From: Simon Davis
Sent: 01 August 2019 12:57
To: Matthew Utting [REDACTED]
Subject: Y/4/19/RES

As previously indicated, I am working on the recommendation/report this week. In doing so, I have come across a few matters which I require your further assistance with. Please note the following points, which require further action from yourselves:

Tree protection plan
Location of trees, categorisation & protection/management proposals at Cinders Lane, Yapton, Arundel

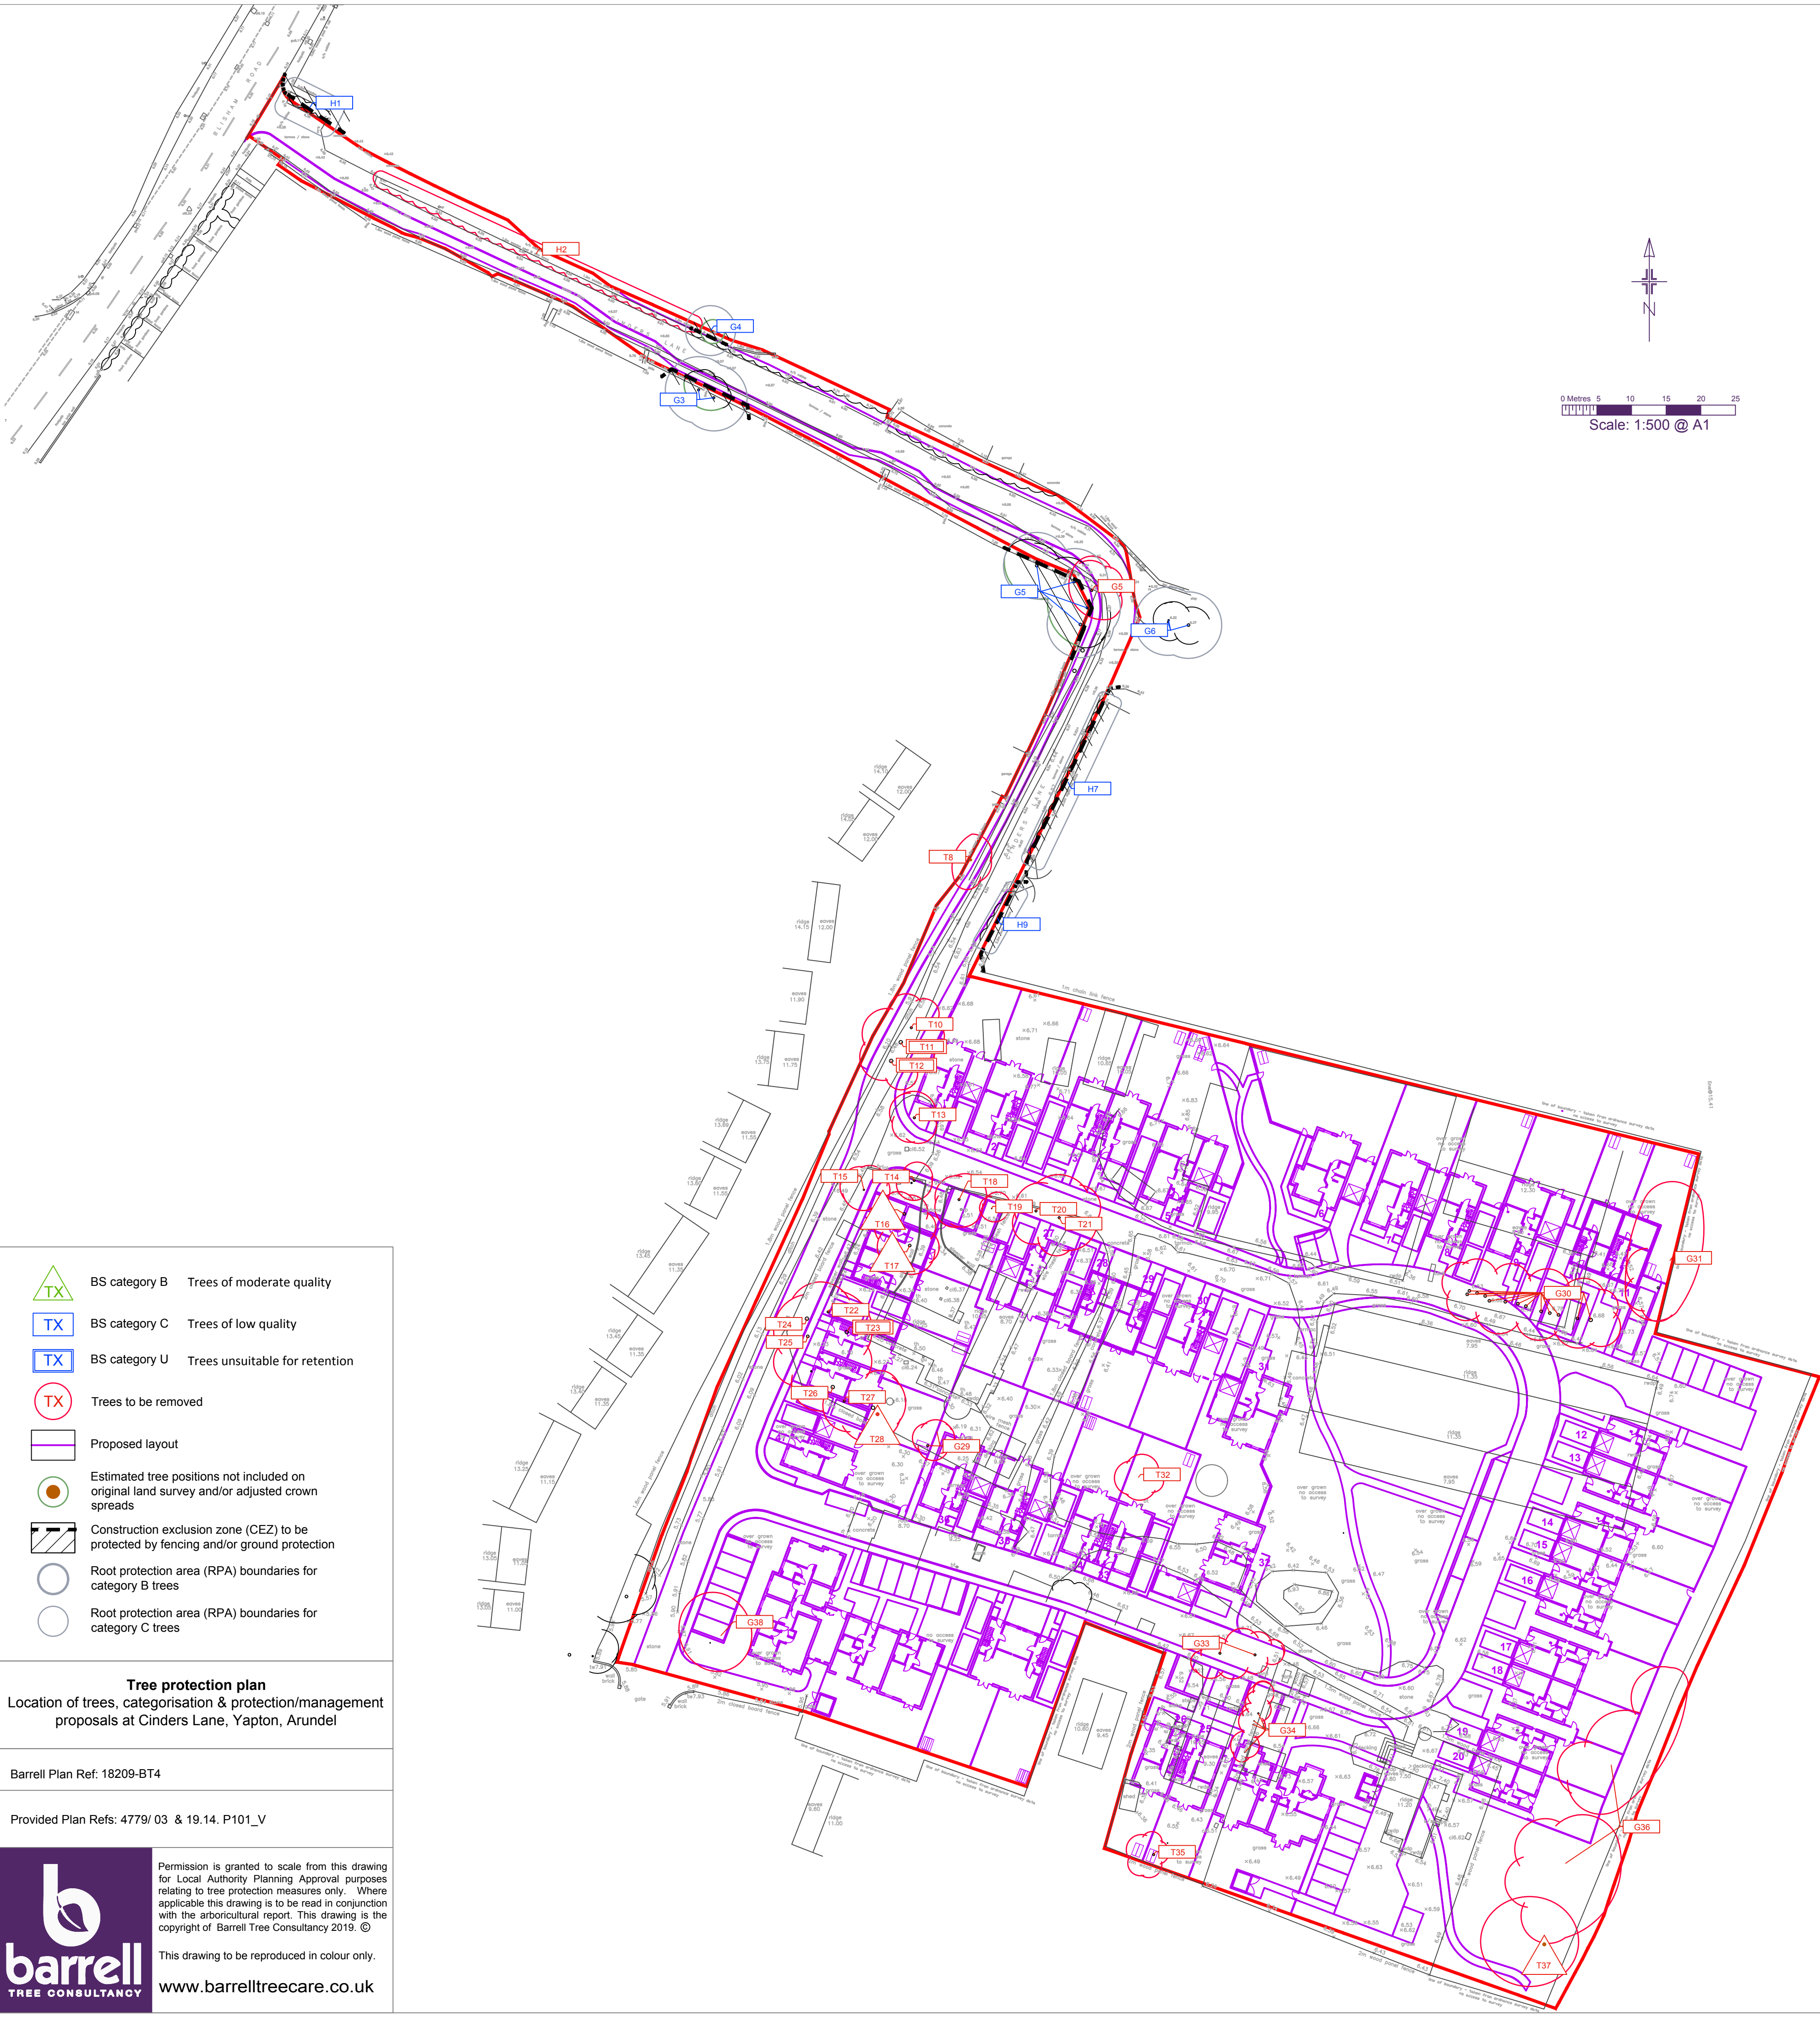
- (6) I need to impose a pre-commencement condition for tree protection. You will receive an email from our system separate to this. I also attach draft conditions - these have not been agreed by my Team Leader but you may wish to comment.
